# OBSERVATION/SUBMISSION TO PLANNING APPLICATION

Case Reference: 324113

**Re: Observation to the proposed development of open-cycle gas turbine (OCGT) and generator with ancillary equipment.**

Location: Pollnagroagh and Rathmorrissy (Townlands), Athenry, Co. Galway

Purpose		PLANNING			
Title		SITE ACCESS SIGHTLINES			
Original Scale	Design/Drawn	Checked	Authorised		
SHOWN at A1	PS	ND	AJB		
Date	Date	Date	Date		
01.12.25	01.12.25	01.12.25	01.12.25		
Status	Drawing Number	Rev			
A2	PEK3-ATK-ZZ-01-DR-CE-901200	0

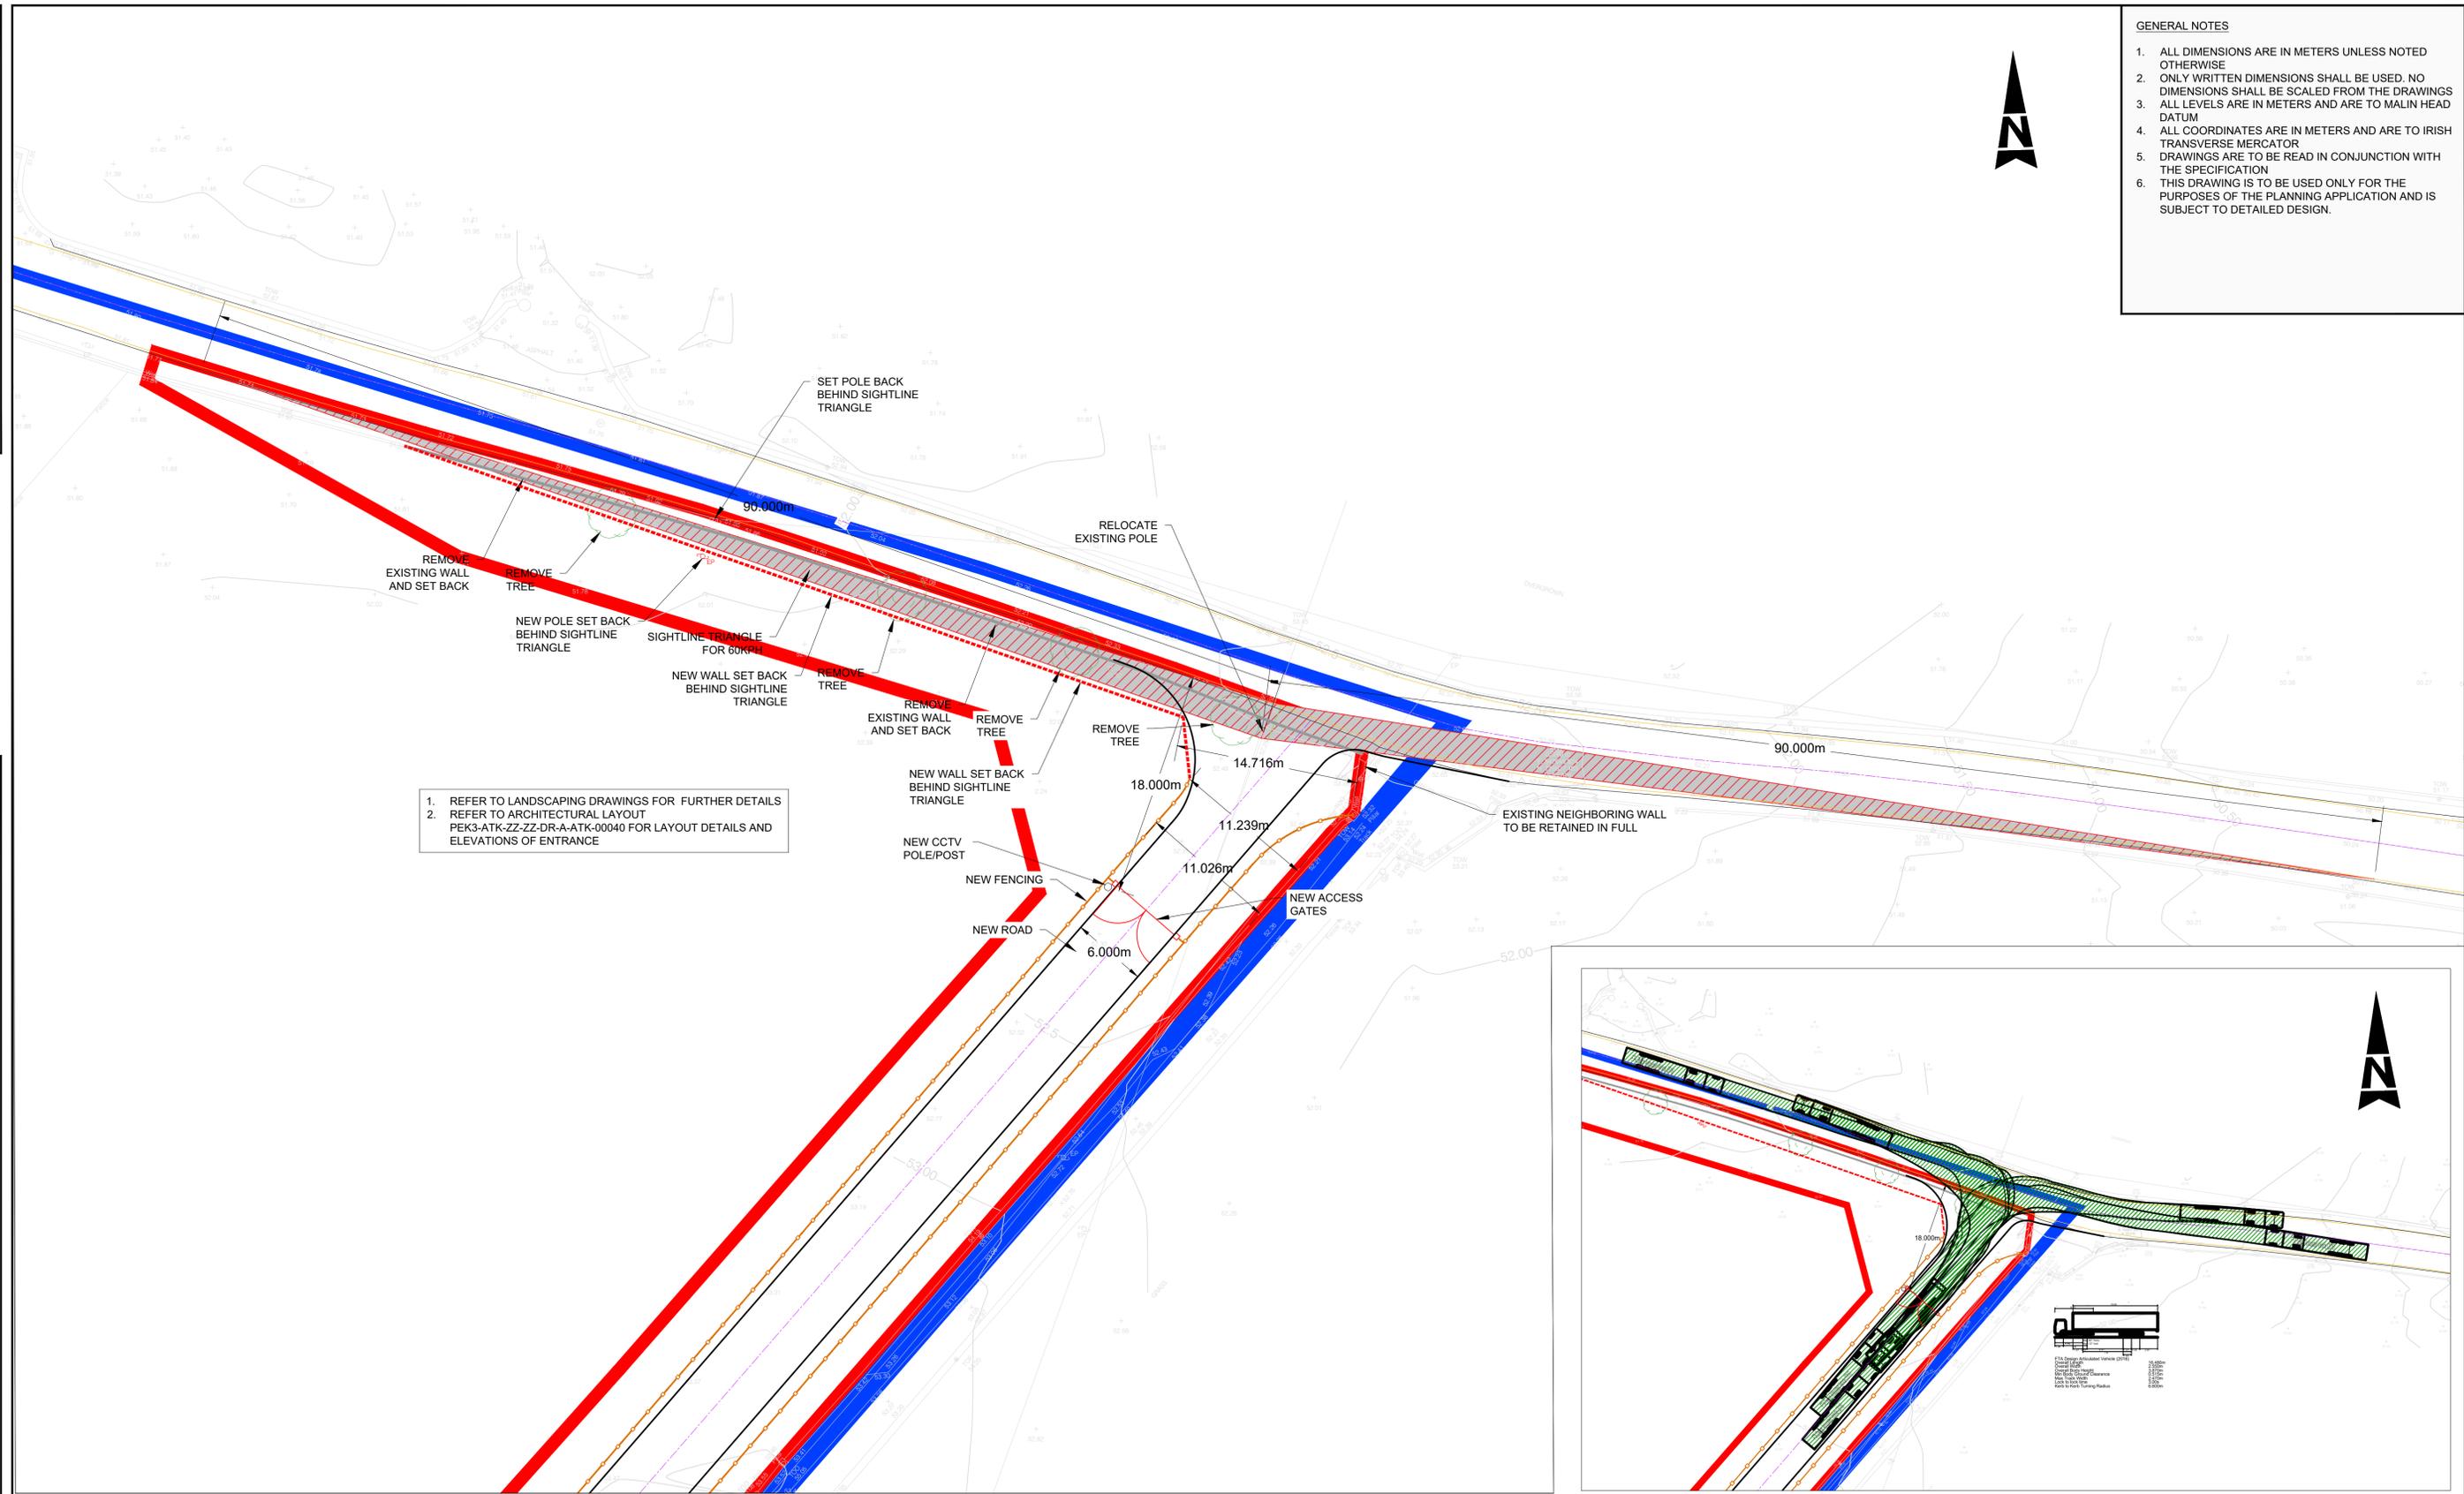
As someone who lives locally and uses this road, I am concerned about road safety in relation to the proposed entrance on the L3103. This stretch of road is already extremely narrow, with no hard shoulder, making it difficult for two heavy goods vehicles to pass safely and leaving no margin for error. Visibility is also poor due to blind dips and sharp bends, meaning drivers often cannot see oncoming traffic in time. The proposed development would increase traffic levels, including heavy goods vehicles, construction traffic, and fuel deliveries such as diesel tankers, all of which require space and clear sightlines that this road does not provide.

Given that these rural roads are used by residents, farm machinery, and school-related traffic, the addition of significant industrial traffic would increase the risk of accidents and create a more hazardous environment. Overall, there is strong concern that the existing road infrastructure is not suitable for this level of traffic and that the associated safety risks have not been adequately addressed.
